**Our Case Number: ABP-316828-23**

**Re:** Tallaght/Clondalkin to City Centre BusConnect Core Bus Corridor Scheme.  
Tallaght/Clondalkin to Dublin City.

# South Dublin County Council Submission on Bus Connects

Tallaght/Clondalkin to City Centre Core Bus  
Corridor Scheme.

Programme Title BUSCONNECTS DUBLIN CORE BUS CORRIDORS INFRASTRUCTURE WORKS			
Drawing Title TALLAGHT/CLONDALKIN TO CITY CENTRE CORE BUS CORRIDOR SCHEME STREET LIGHTING			
Drawing File Name	Sheet Number	Status	Rev
BCIDA-ACM-LHT_RL-0809_XX_00-DR-EO-0008	08 of 56	A	M01

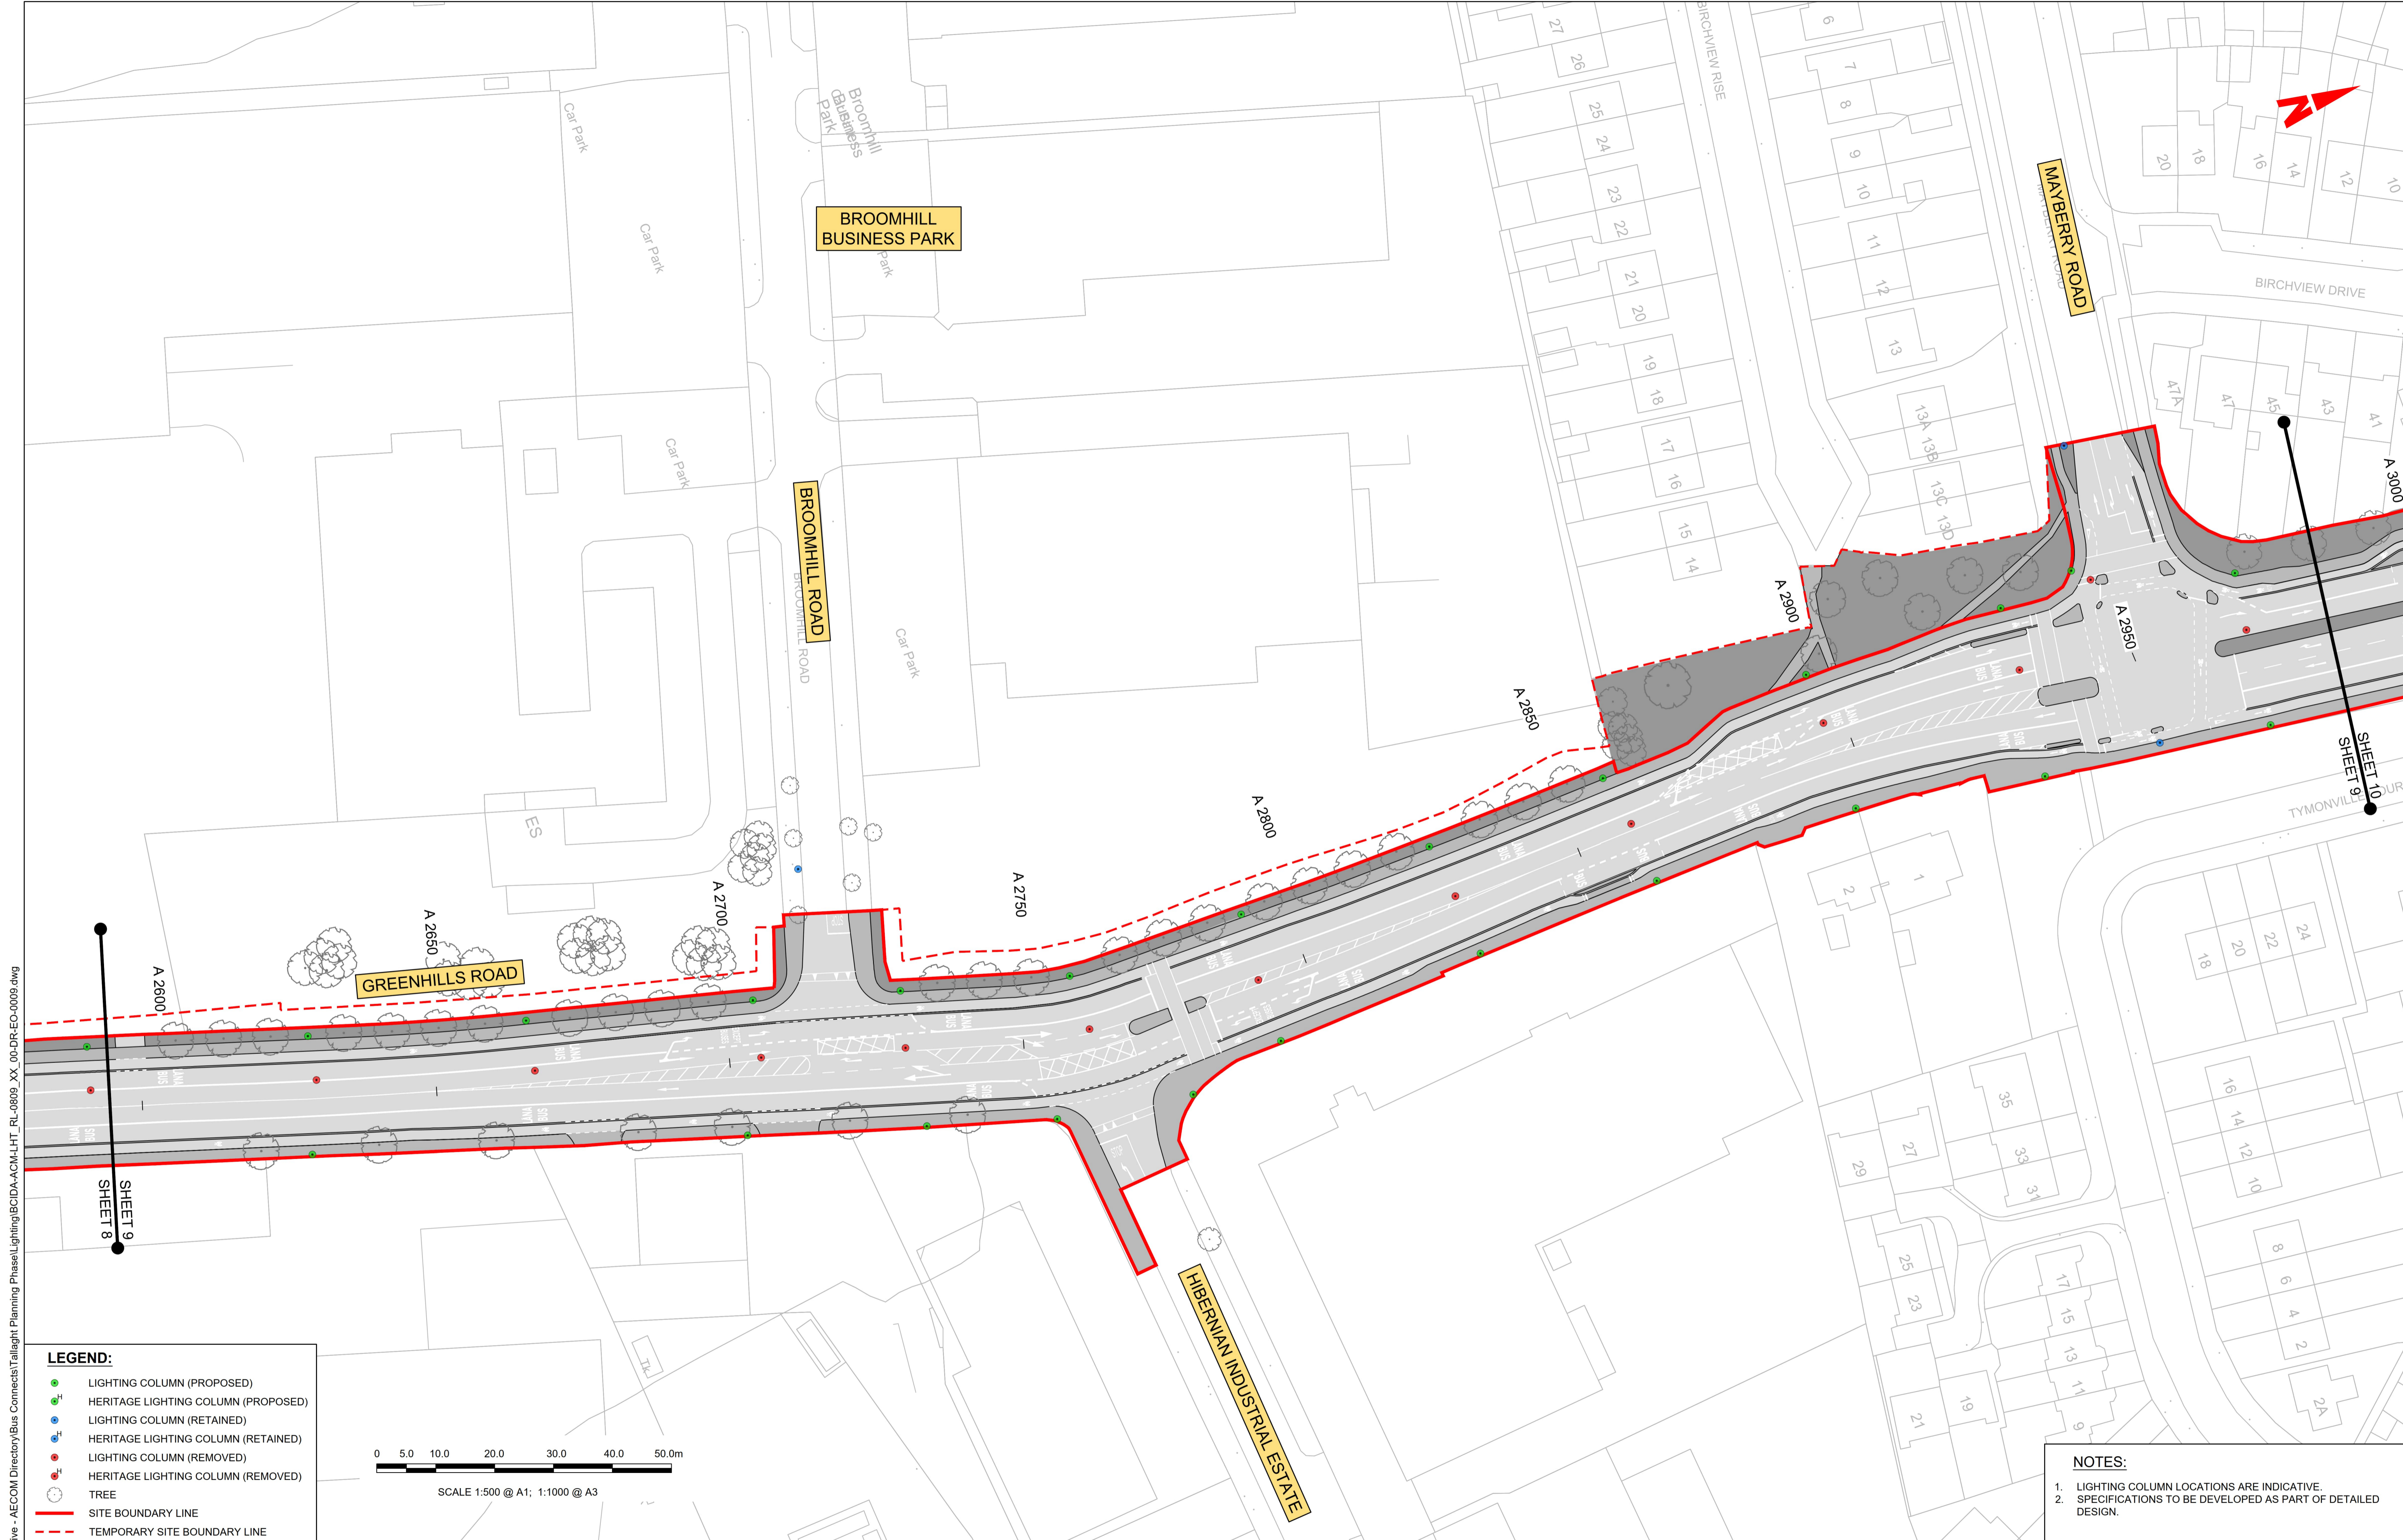
- (d) There are several locations where the cycle lanes only extend short distances off the main bus connects into connecting roads and simply end where there are no existing cycle lanes. Wherever possible cycle lanes should be extended to connect into existing cycle lanes to help provide a joined-up network. For example, this would be particularly useful at the Airtown Road which is an important link road to Tallaght Square. **(Sheet 8 of 56 on General Arrangement Drawings)**

Programme Title BUSCONNECTS DUBLIN CORE BUS CORRIDORS INFRASTRUCTURE WORKS			
Drawing Title TALLAGHT/CLONDALKIN TO CITY CENTRE CORE BUS CORRIDOR SCHEME STREET LIGHTING			
Drawing File Name	Sheet Number	Status	Rev
BCIDA-ACM-LHT_RL-0809_XX_00-DR-EO-0009	09 of 56	A	M01

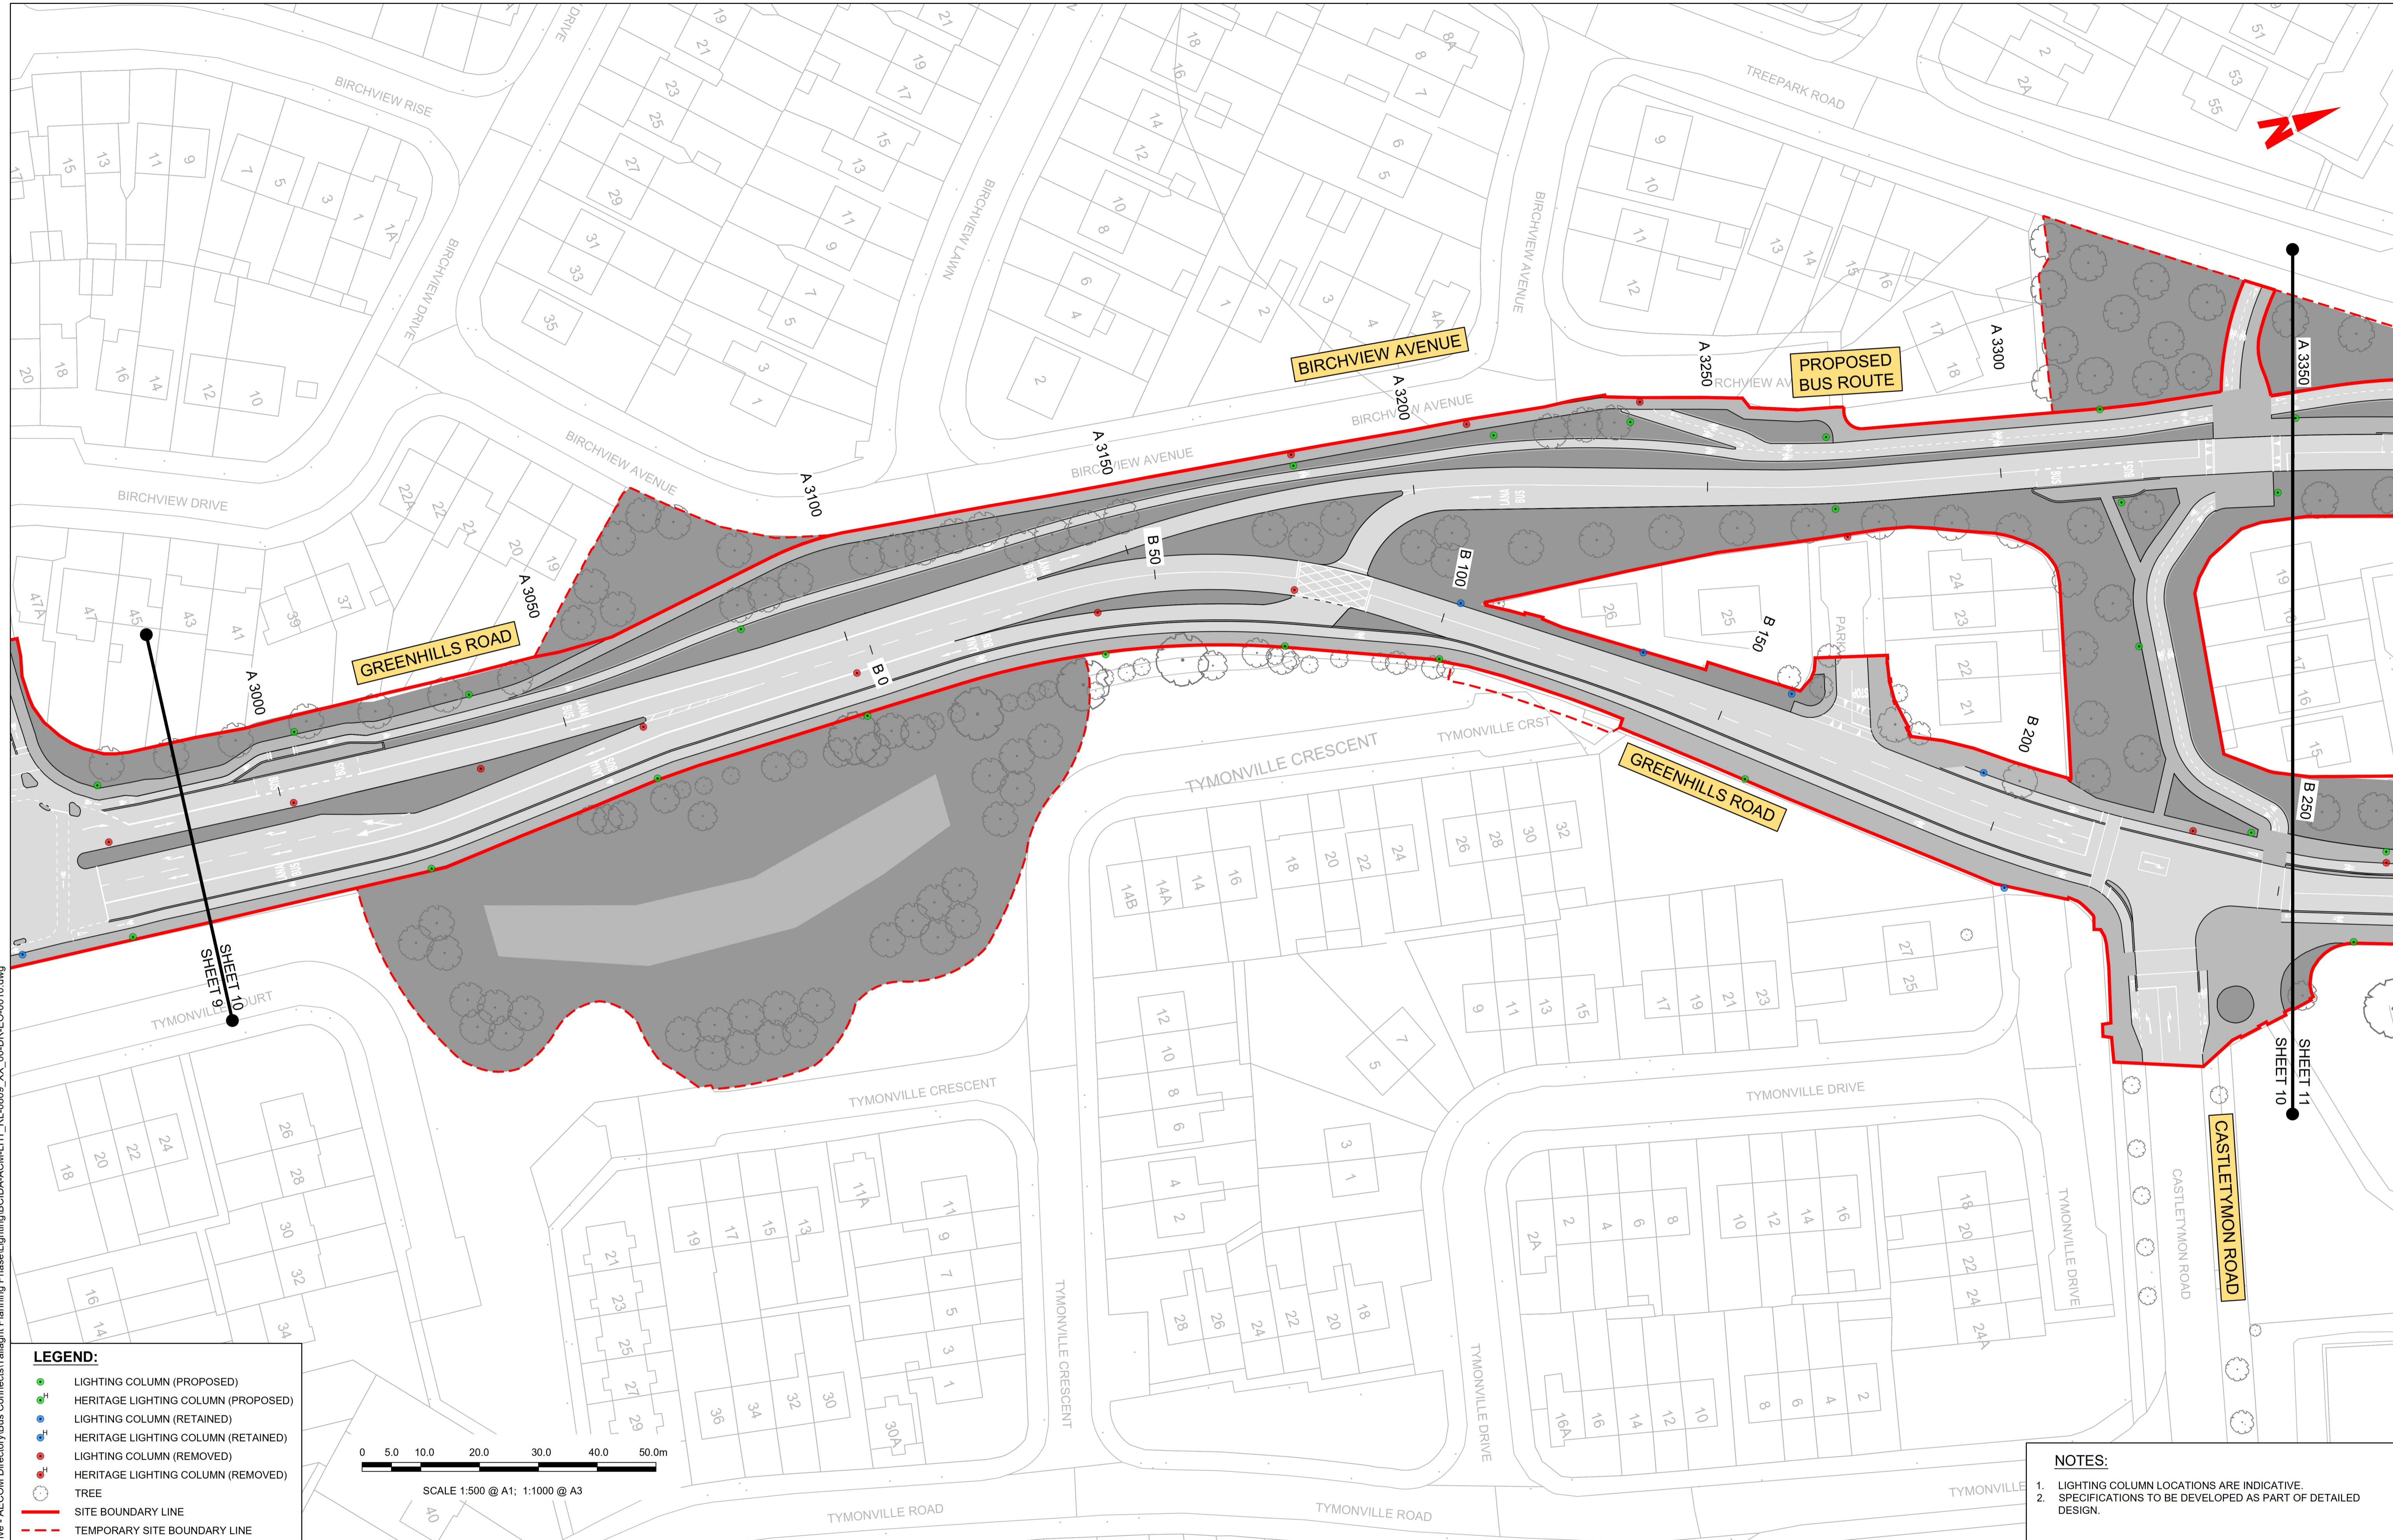
- (e) The scheme should clearly set out how the NTA will re-provide a high-quality open space at Mayberry Road and Birchview Avenue as the scheme does affect the existing amenity of Green open space at these locations. The proposal to use this open space as a temporary site compound could create negative impacts on surrounding residential areas and the final design and layout, visual impact, hours of operation, traffic and noise should be secured by planning condition for agreement with the Local Authority. **(Sheets 9, 10 and 11 of 56 on General Arrangement Drawings)**
